May 5, 2014  
BCE File.: 13136

**Re: Revisions to 120 Veranda Street Subdivision Plans**

Enclosed please find the revised plans and stormwater report for the property at 120 Veranda Street in Portland. At your request, we made the following changes since the last submission on April 1, 2013:

D-100

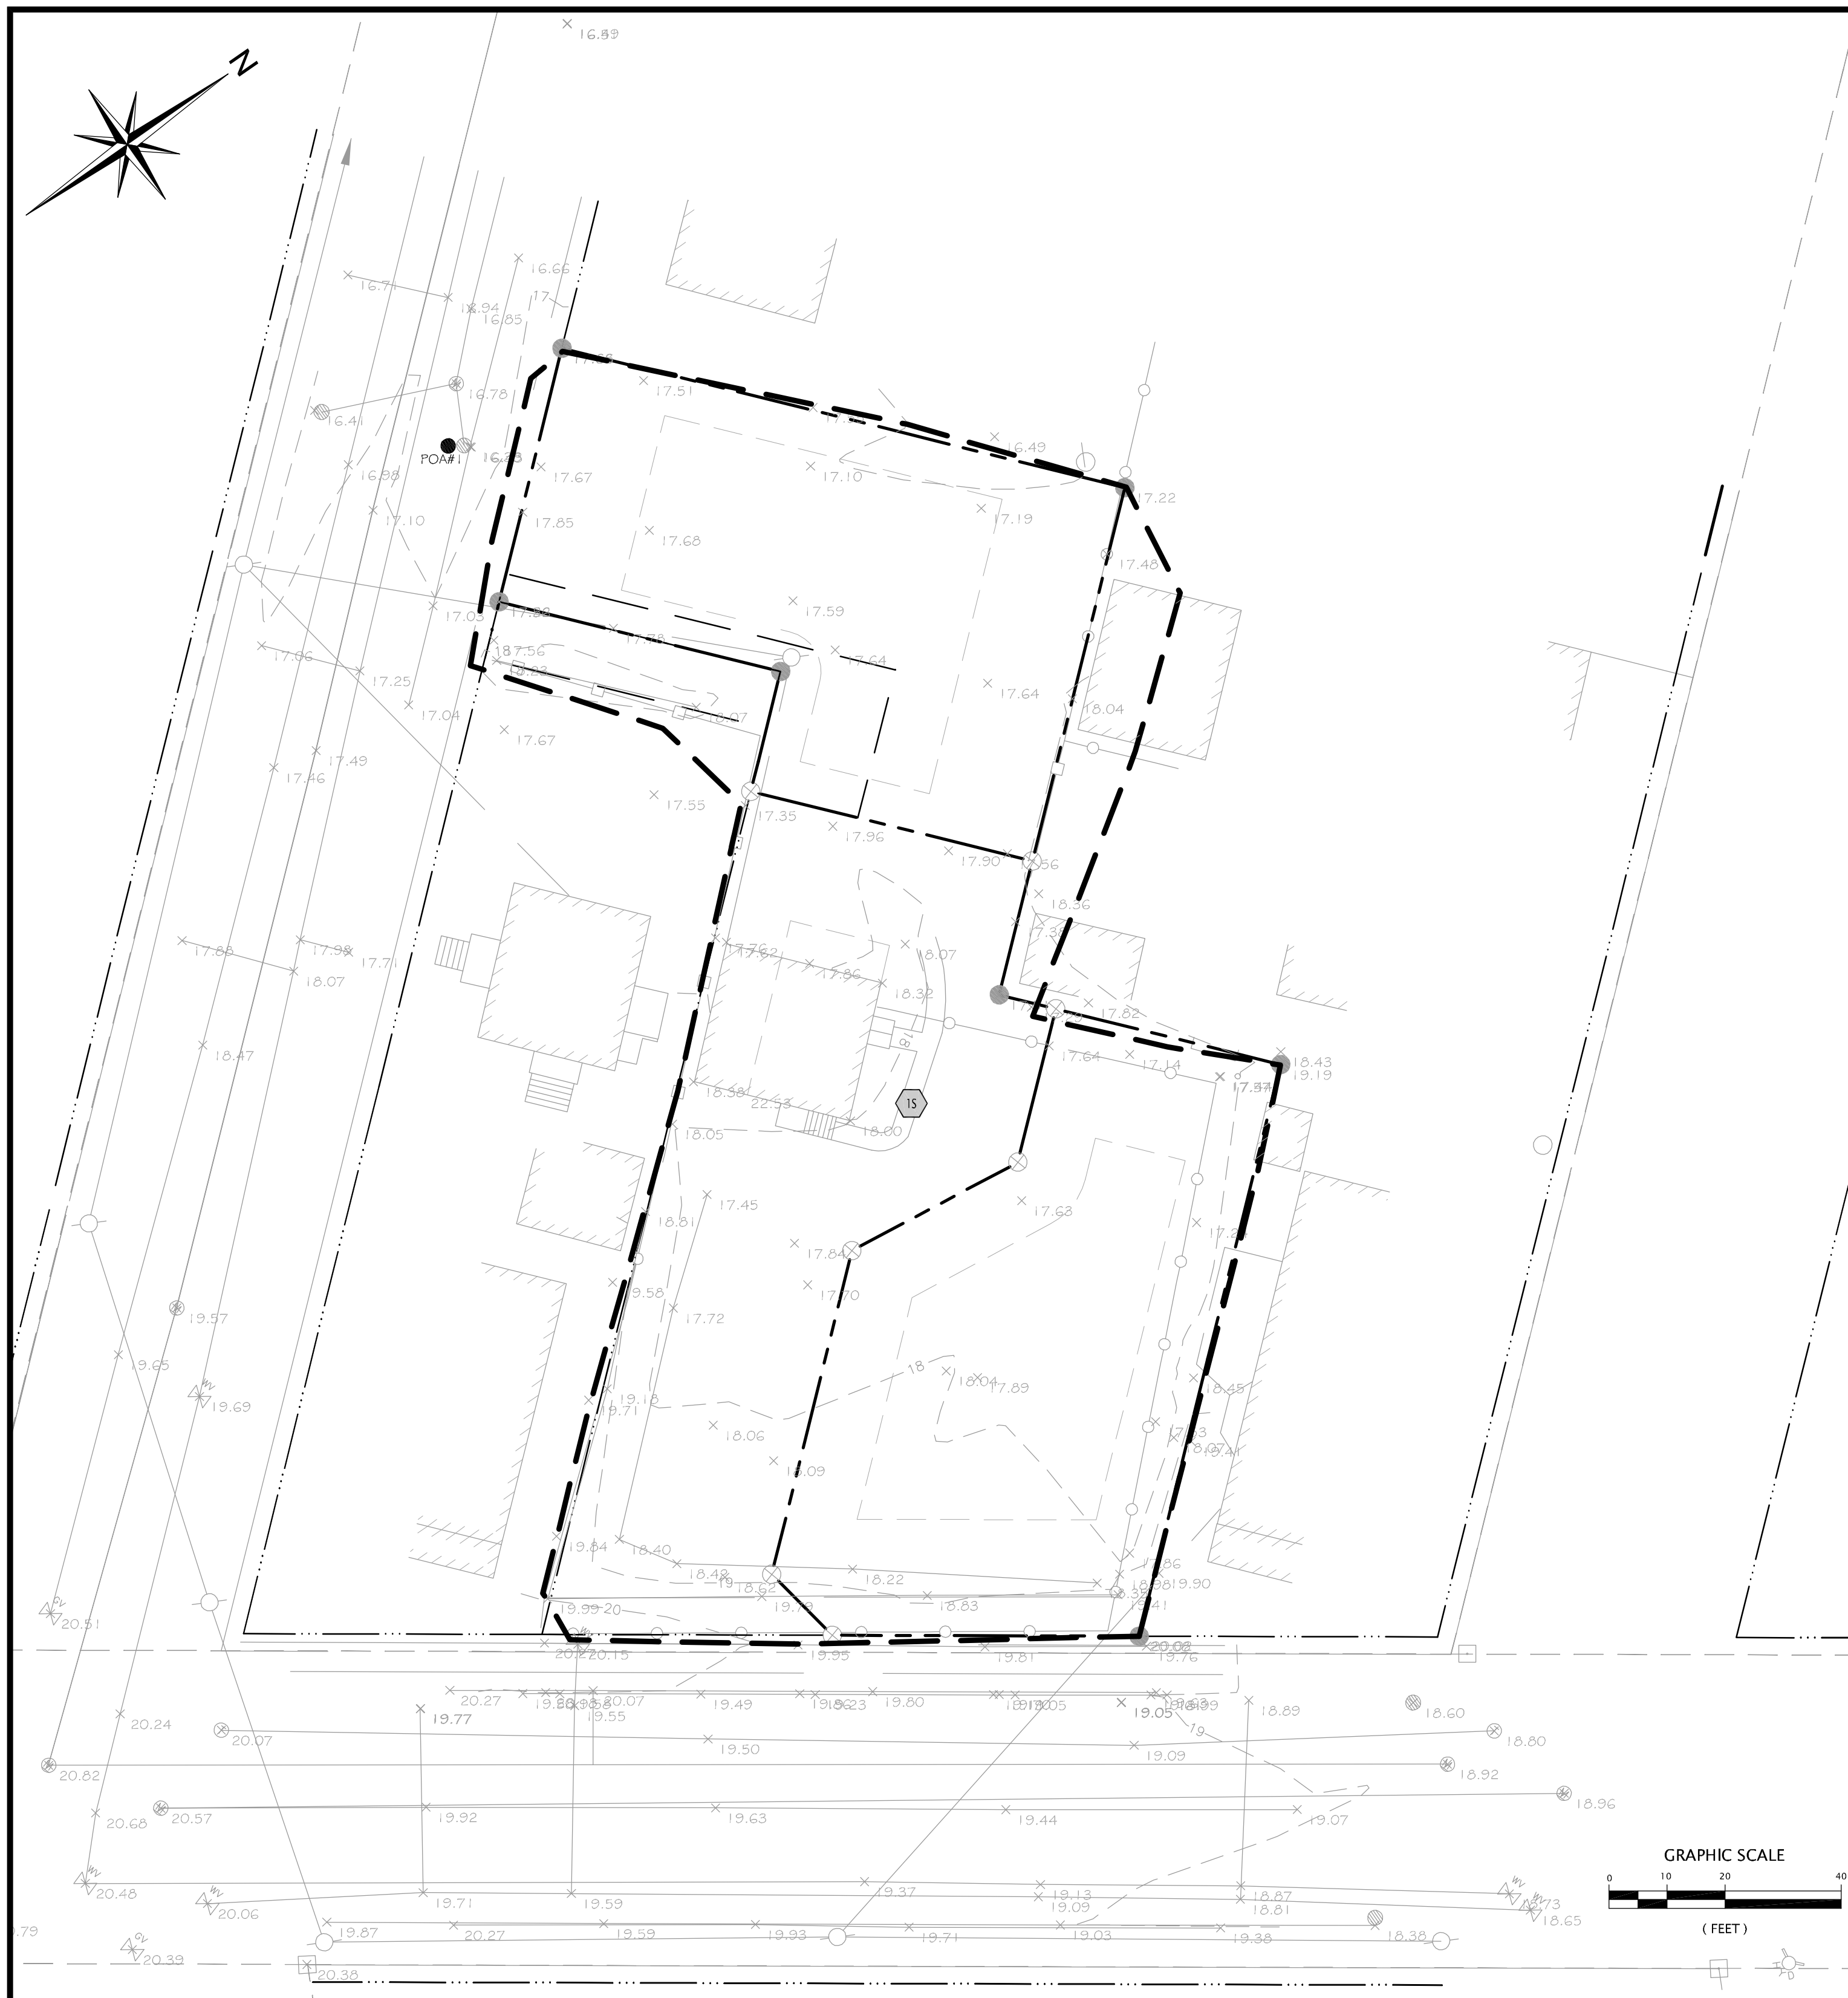
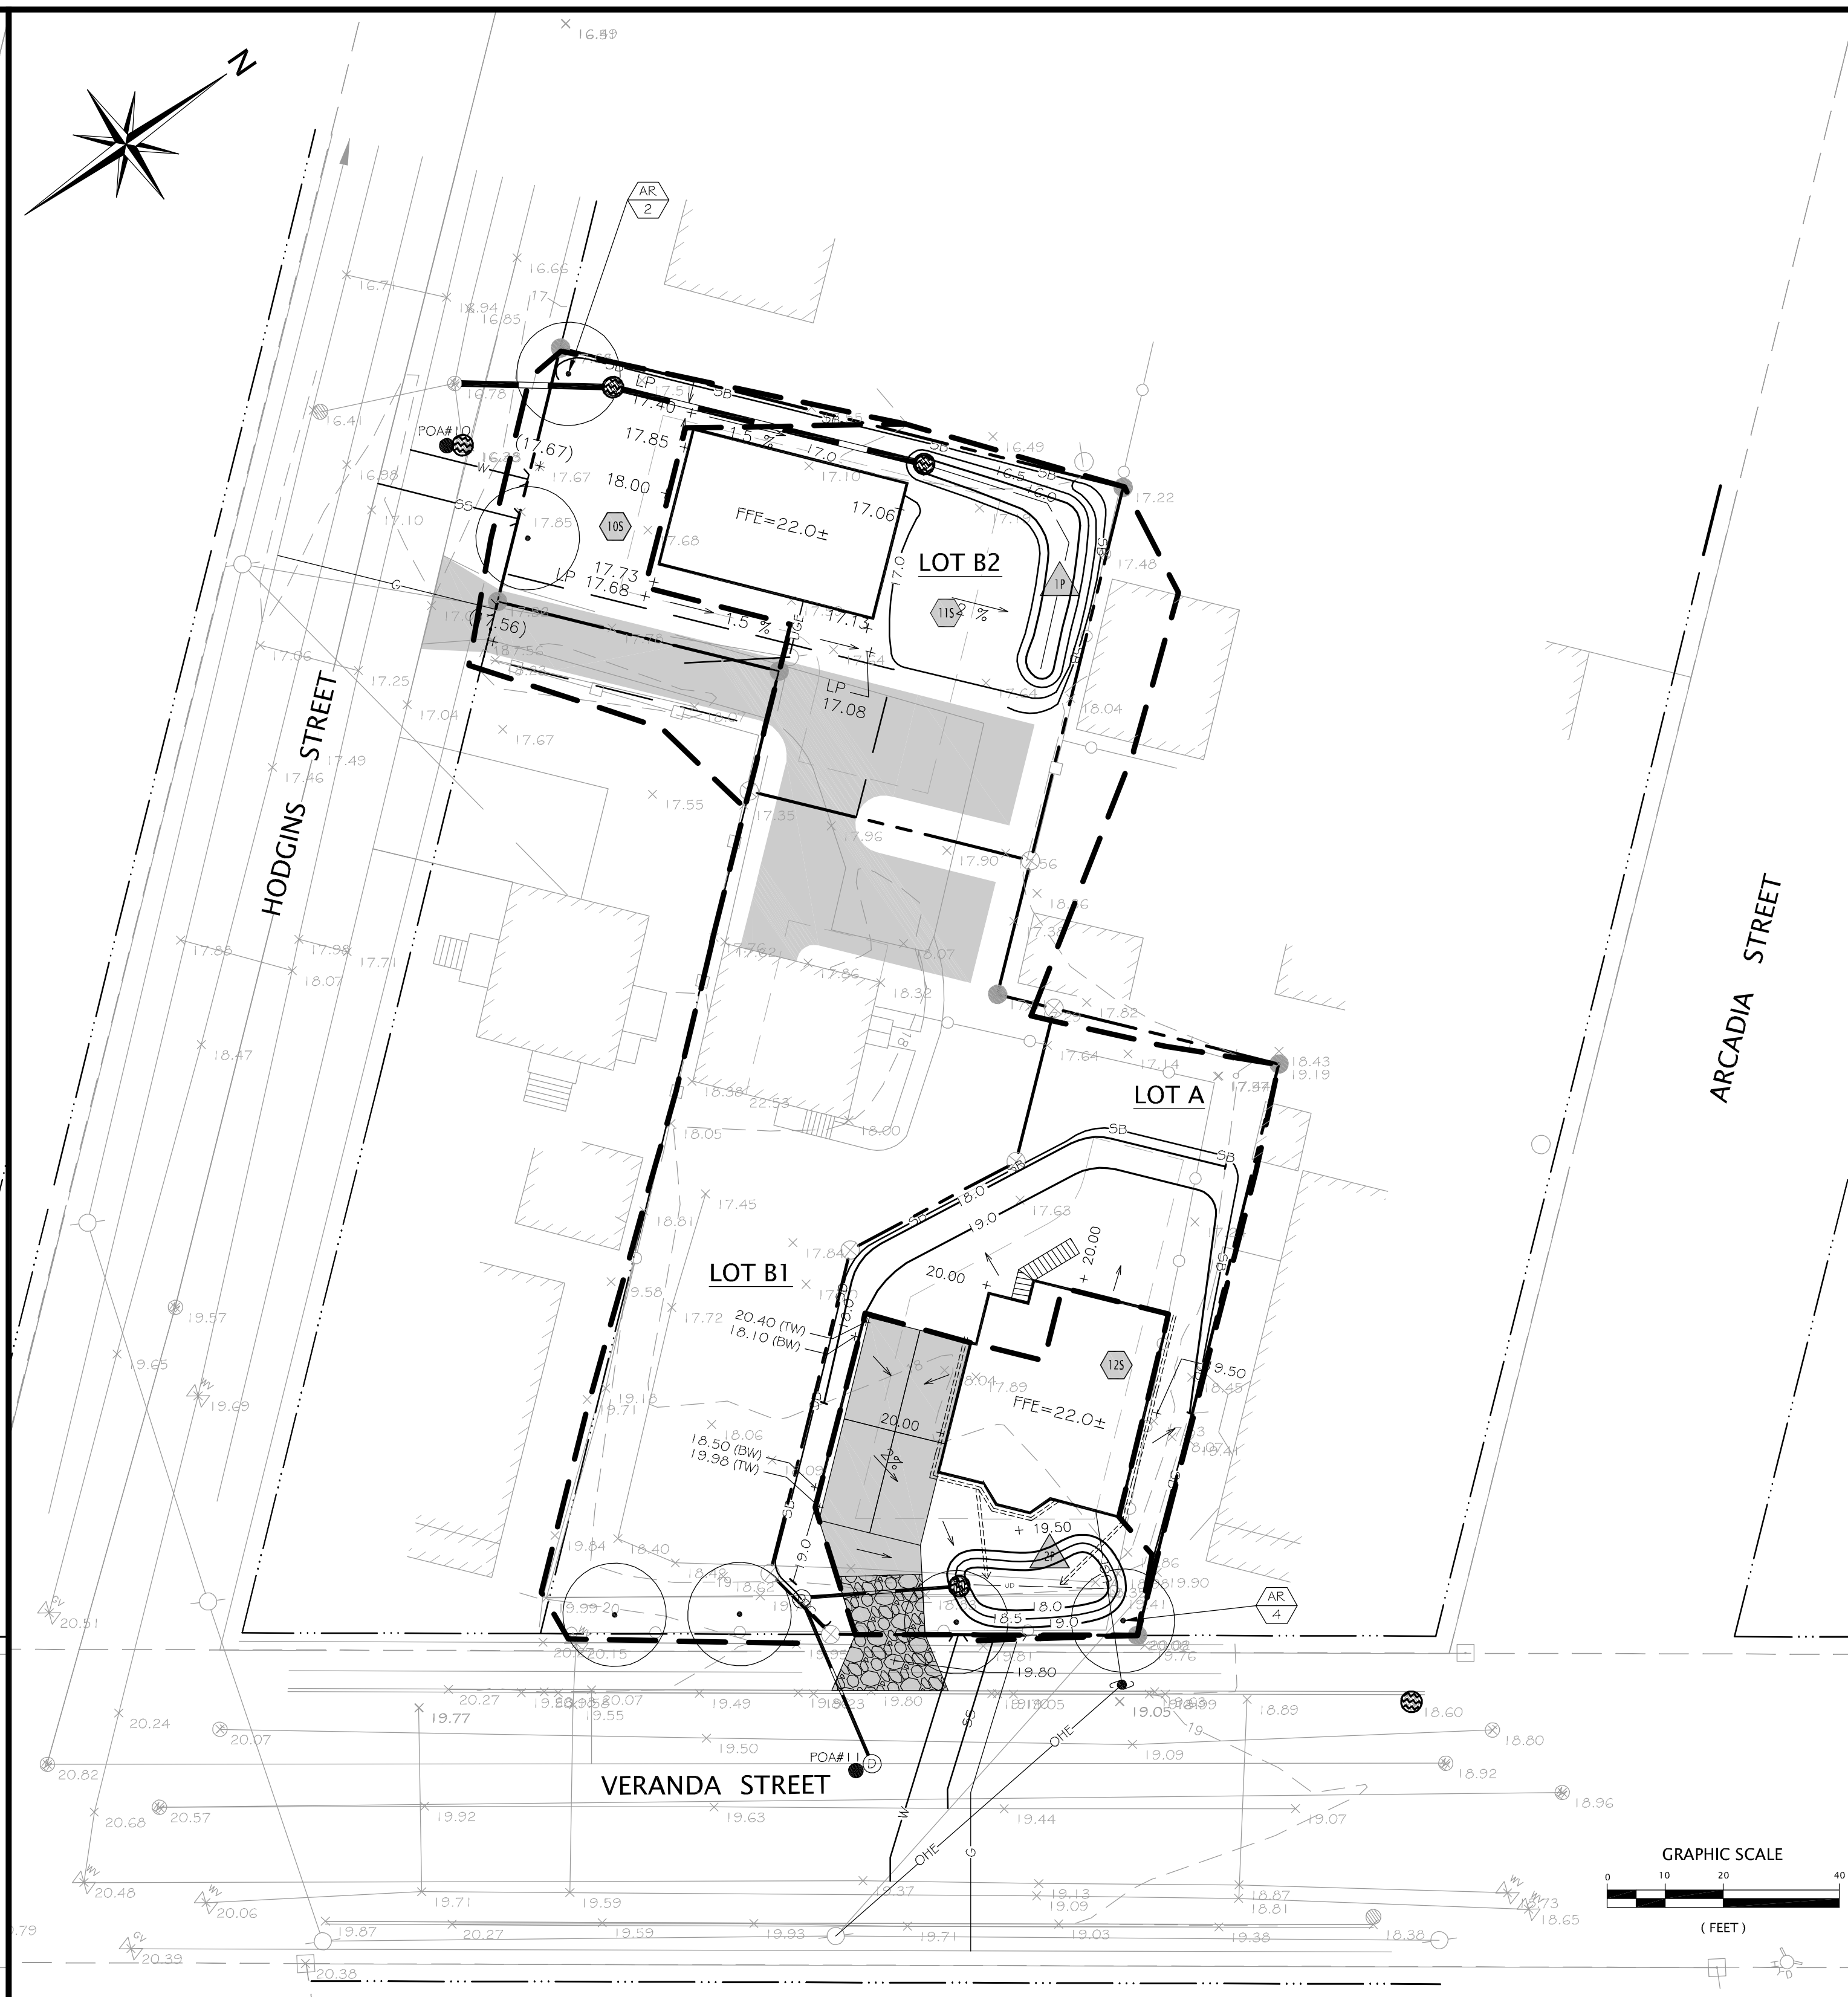
- Reduced the Lot A proposed building footprint by 168 sf,
- Shifted the building on Lot A by 4 feet towards the northeasterly property line,
- Added two 9'x18' parking spaces for a total of four spaces.
- Adjusted DMH 2 for the elevation of the drain pipe stub to DMH 1, which was installed slightly higher to avoid other utility conflicts in the ROW,
- Moved the proposed underdrained grassed soil filter from the back of the house to the front
- Updated Sheets C-100, C-300, D-100 and the Stormwater Report.

As a result of the changes above, the peak flows at Point of Analysis 11 remain the same for the 2 year storm and decrease for the 10 and 25 year storms by 0.16 and 0.13 cfs respectively. These reductions are due to redirecting some of the Lot A impervious roof area toward Point of Analysis 10, where the post-development peak flows remain at or below the pre -development ones.
